**From:** John Charette <john@charette-design.com>  
**To:** Liv Chase <livchase@yahoo.com>, Tracie Reed <traciereed@dextrouscreative...>  
**CC:** Ann Machado <AMACHADO@portlandmaine.gov>  
**Date:** 8/18/2014 10:13 AM  
**Subject:** Re: 180 Washington Ave - Permit #2014-01749  
**Attachments:** S 1 Structural framing plan.pdf; S 2 Structural framing plan.pdf; S 3 Structural Framing Plan.pdf; A 1.2 Floor Plans.pdf; C 2 Site Plan.pdf

> I have completed my initial zoning review and at this time I can't sign  
> off. I need the following:

A1.3

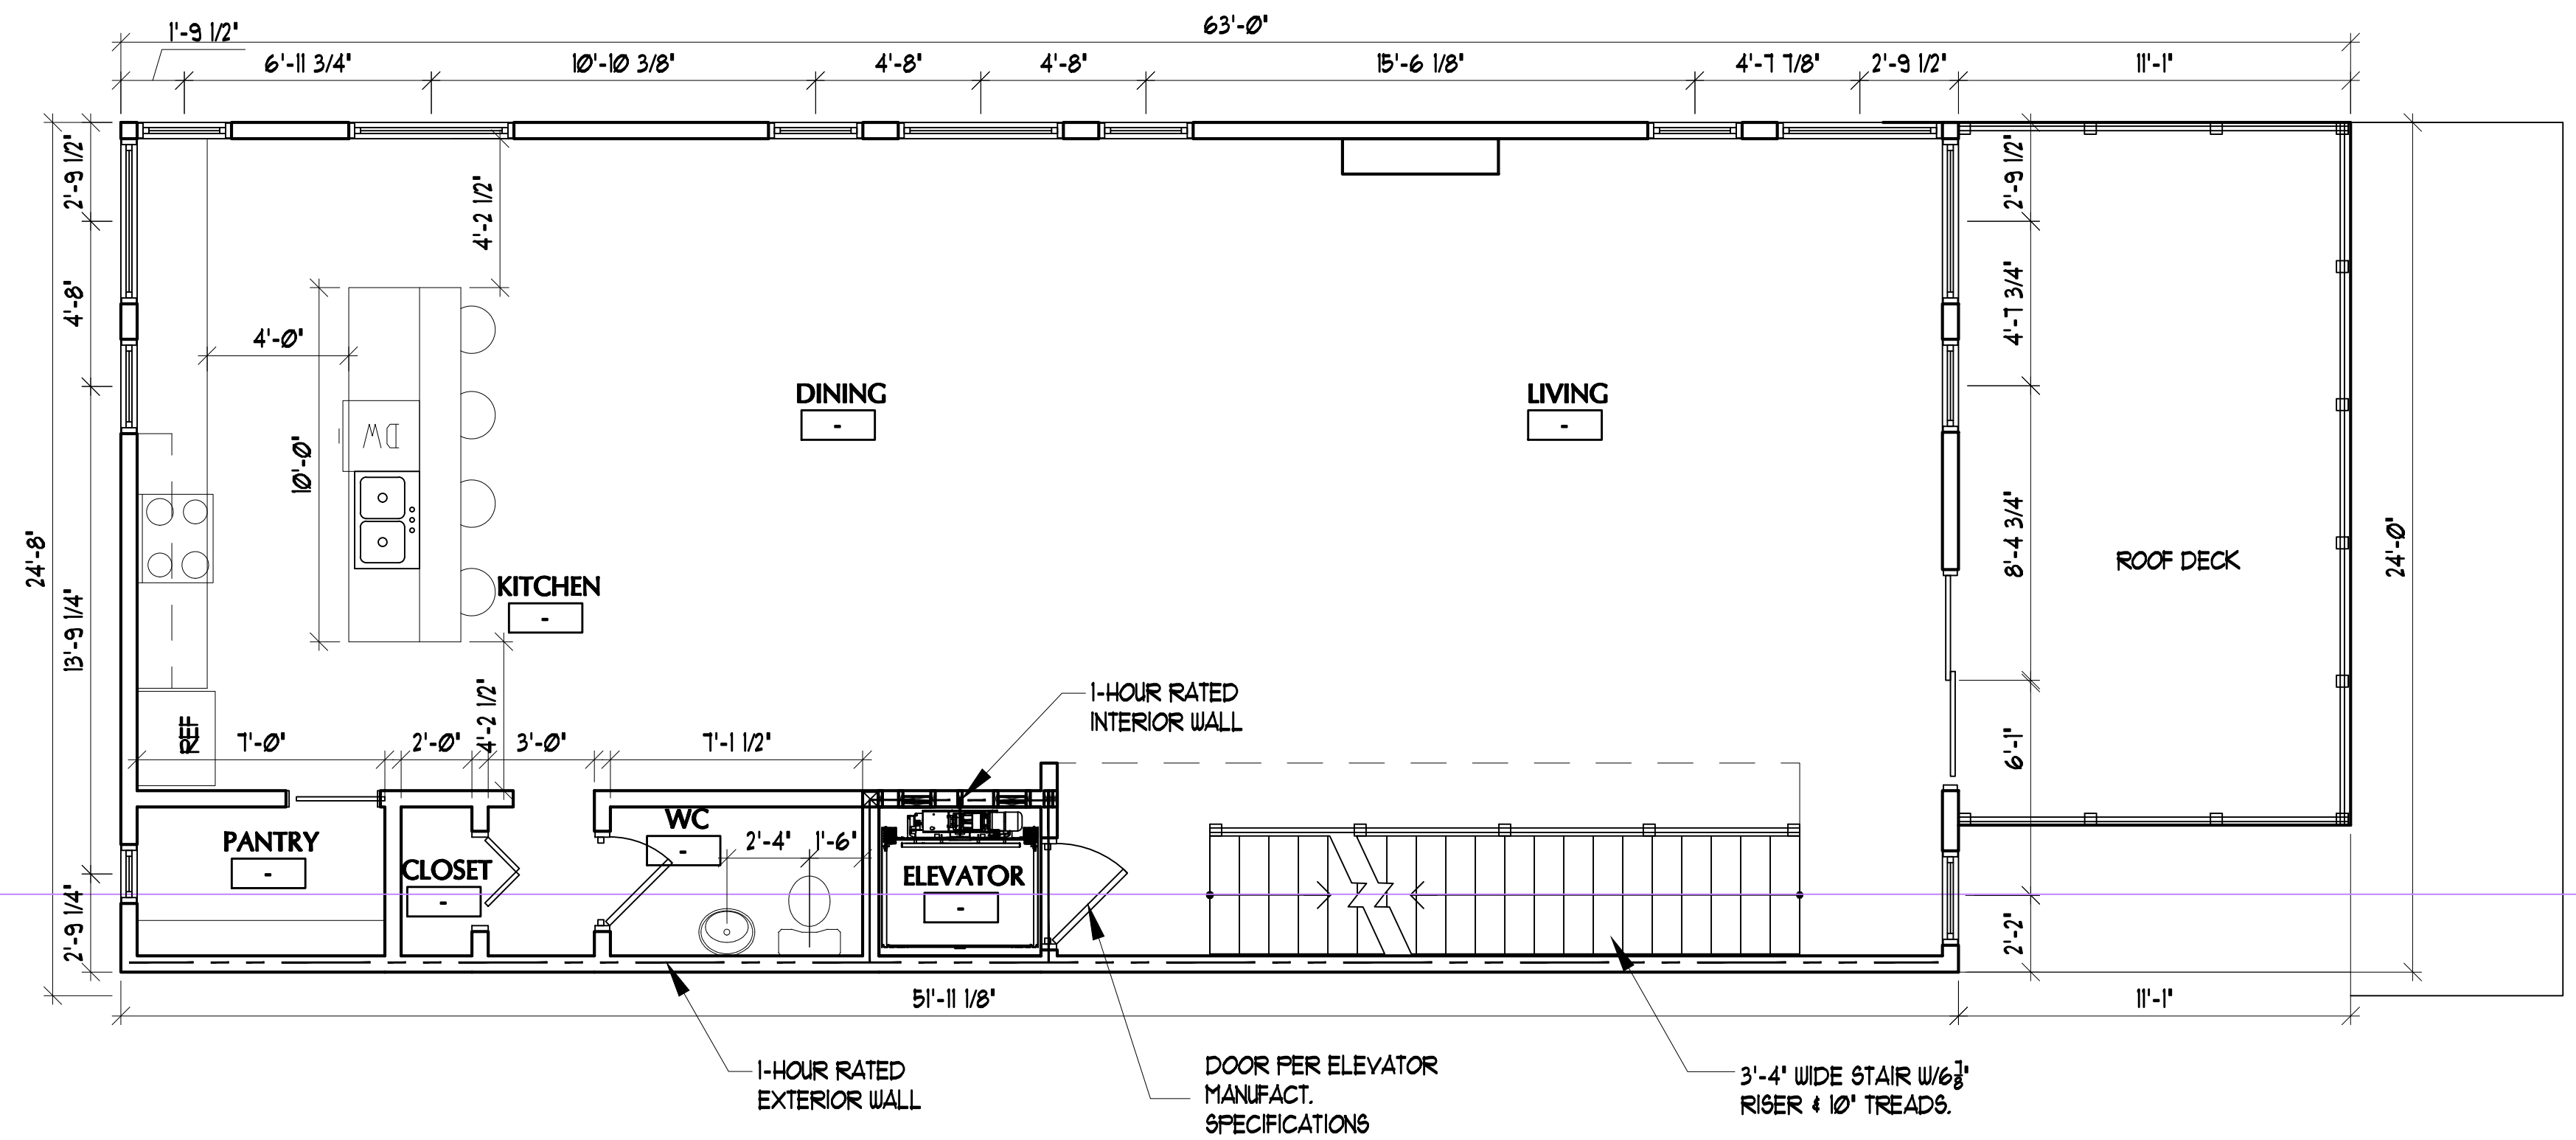
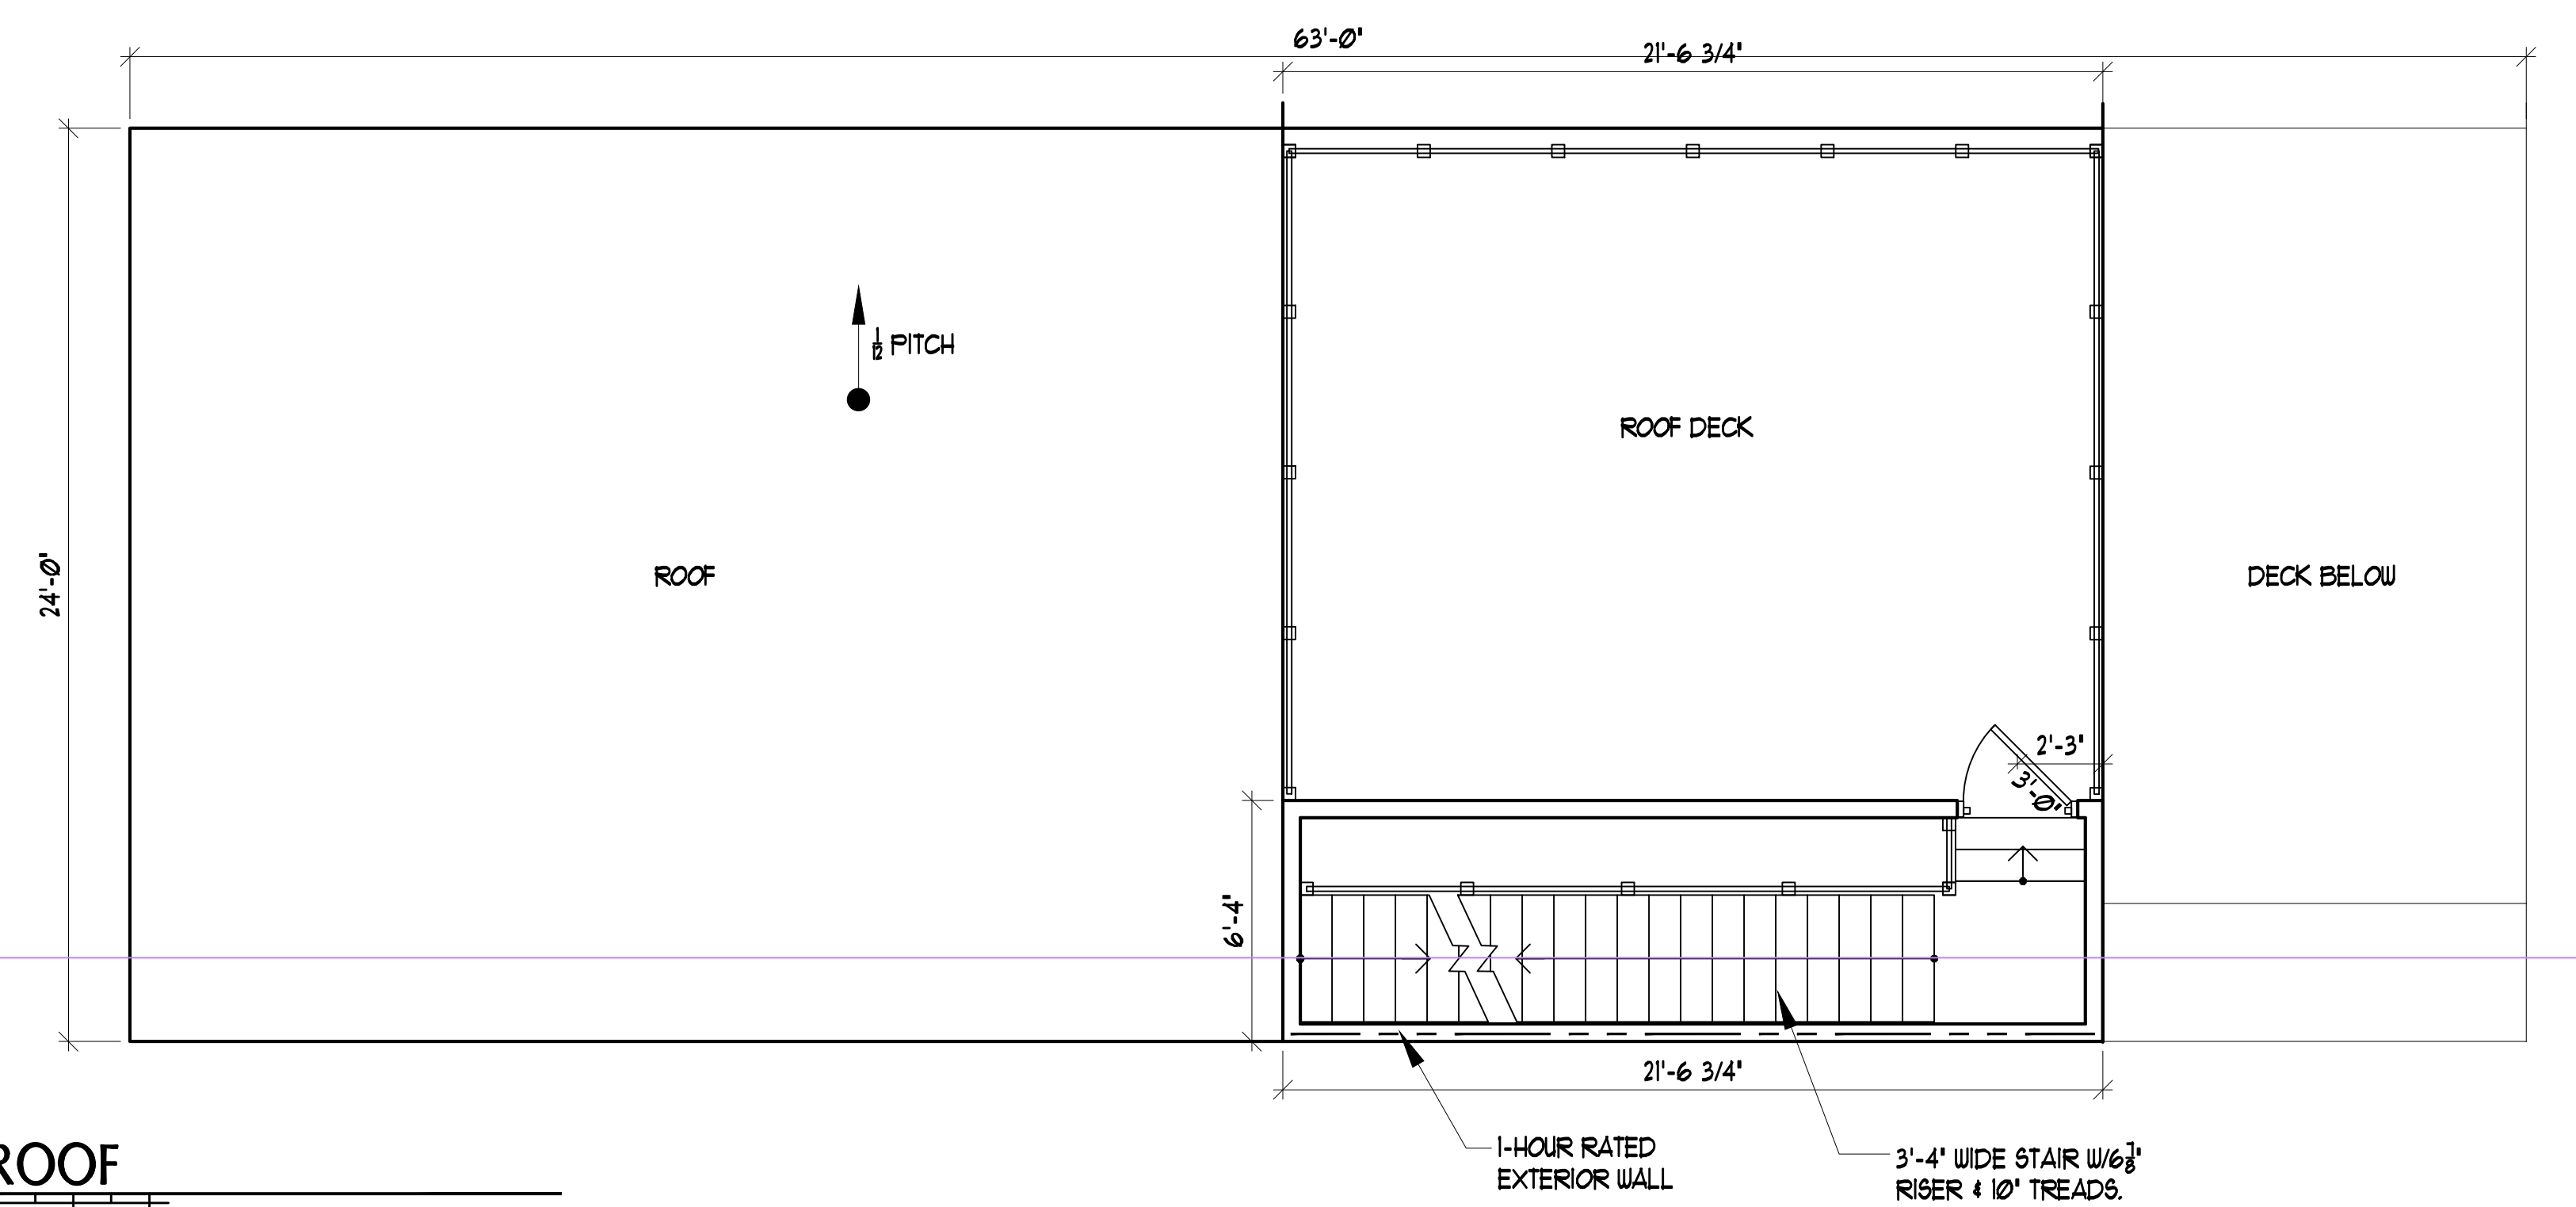
- > but this is not shown on the floor plan.
- > - the third floor plan matches the elevations.
- > - the framing plans match the elevations and not the floor plan dimensions.
